From:
Sent: 13 September 2024 10:21
To: DC Admin
Cc: Molly Storer
Subject: OBJECTION Application 2024/92024 - 14 Bankfield Terrace

Application 2024/92024 - 14 Bankfield Terrace Erection of a single storey side extension and alterations.

Plans - Proposed Ground Floor Plan

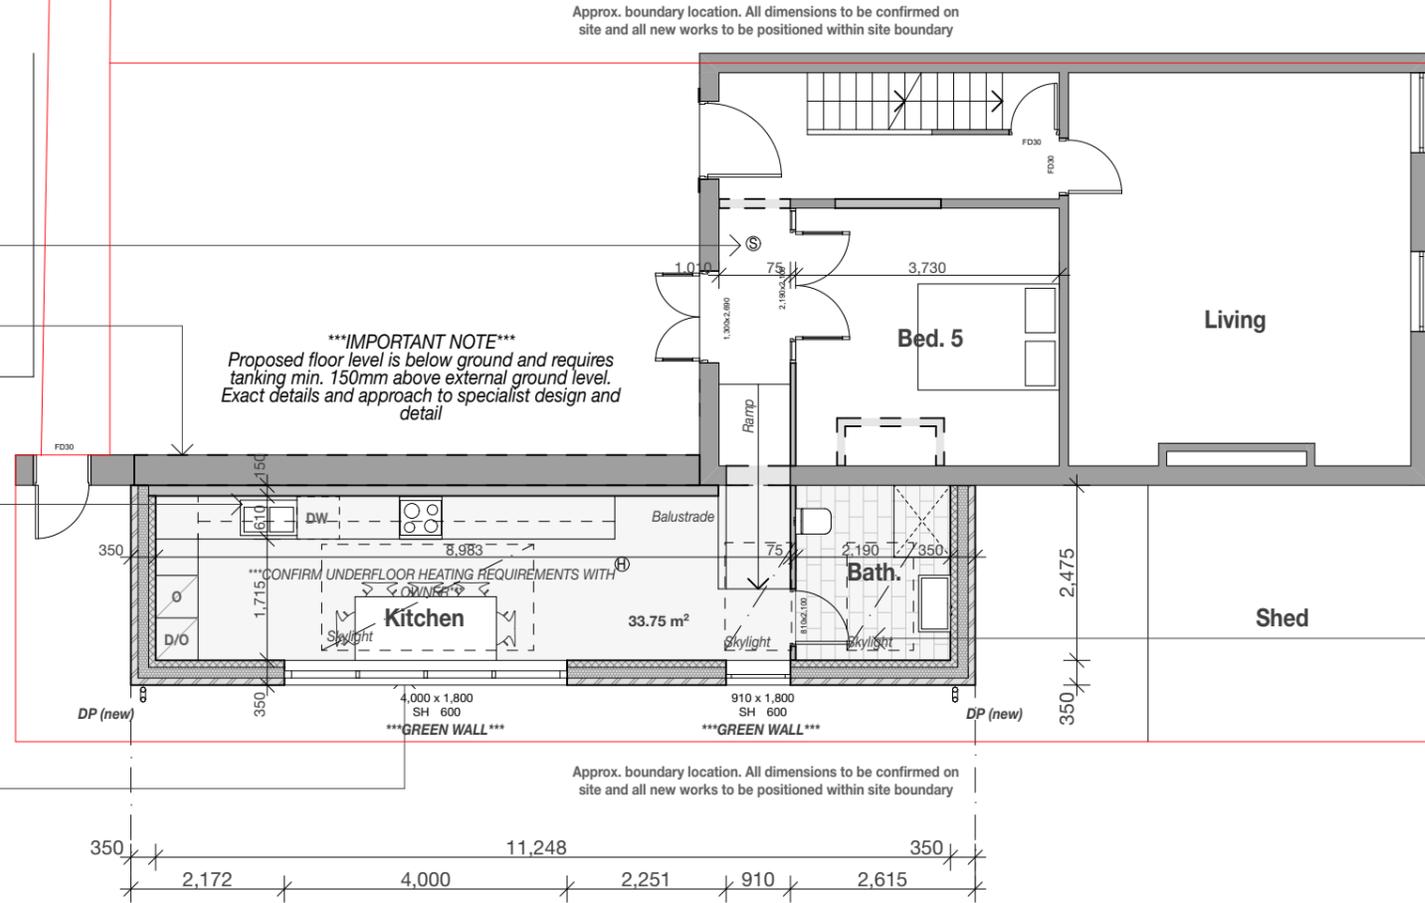
Despite the removal of the bi-folding doors and reduction in height, the substantial massing of the extension remains a significant concern. There appears to be a window to the outward facade and the extension still extends considerably beyond the building line. As the neighbouring property, no.

Site Plan - Proposed

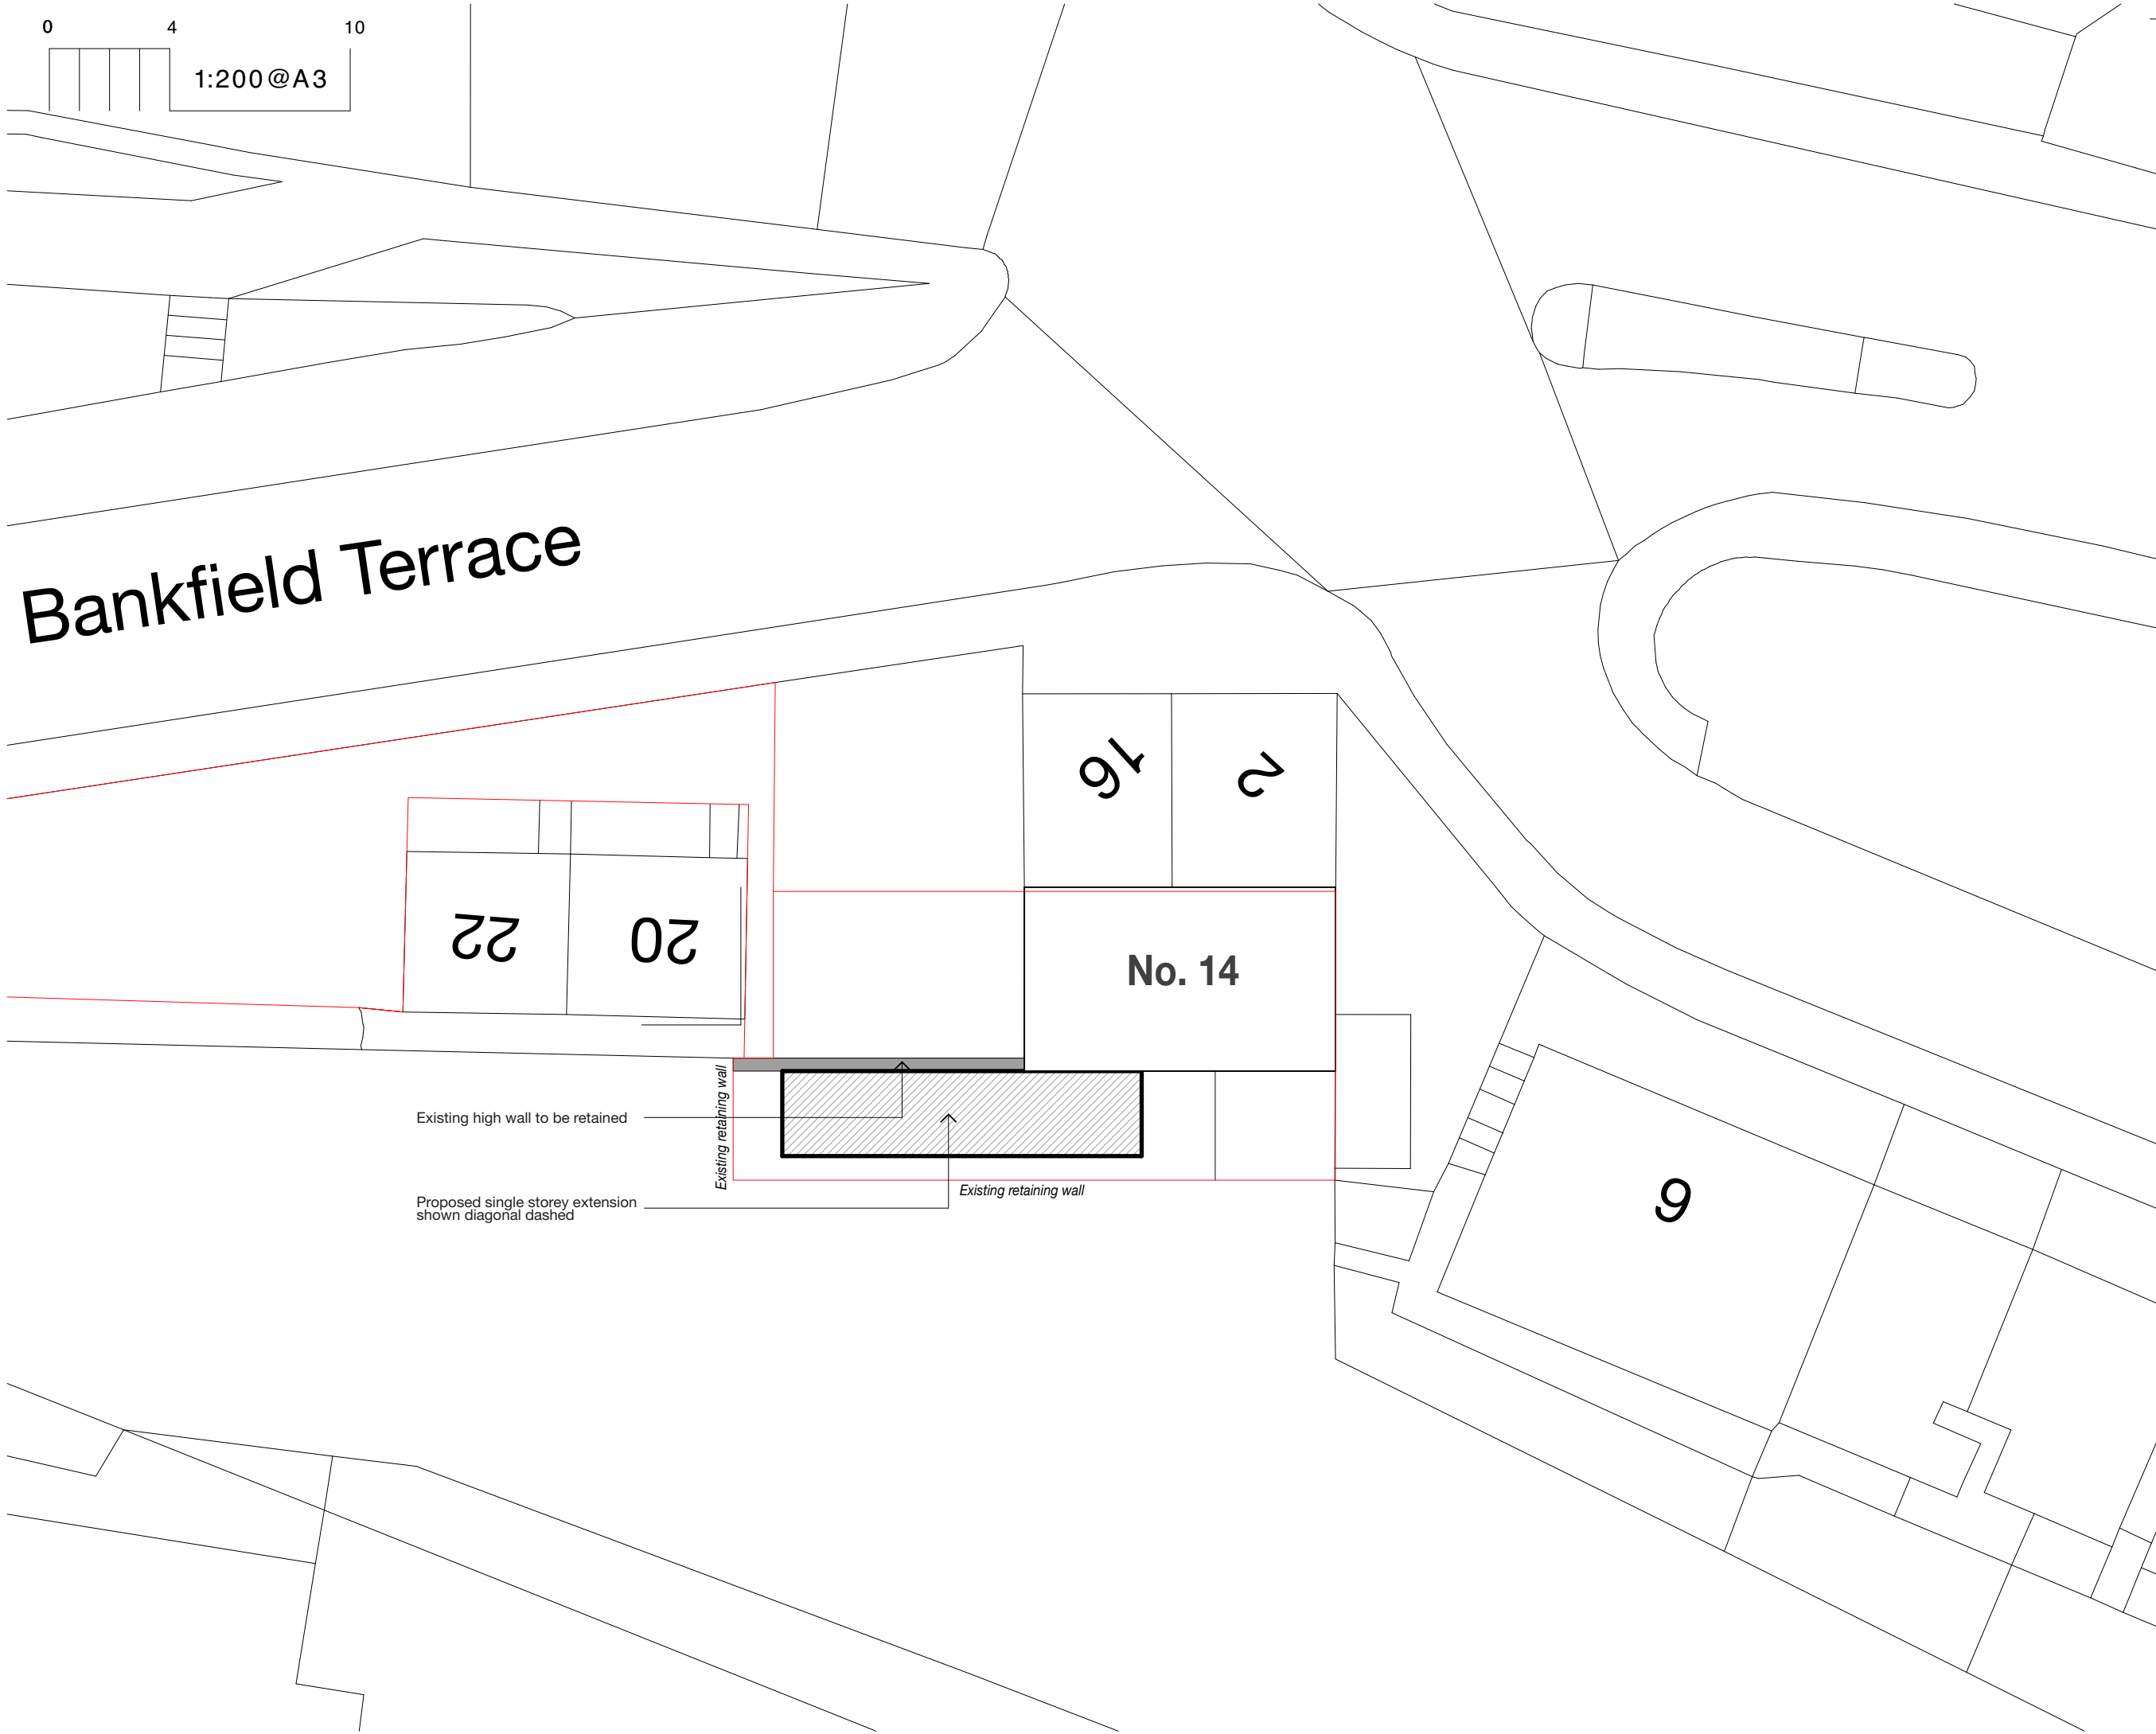
There have been historic stability issues with the retaining wall adjacent the proposed extension site, including a previous collapse. The planning application documents do not adequately address these concerns. There are fears the retaining wall may collapse again, which is a safety risk to all residents of Bankfield Terrace. Additionally, the proposed green wall could exacerbate instability issues by adding extra weight. Any mitigation measures, such as buttresses, would further limit access and contribute to the overbearing nature of the scheme.
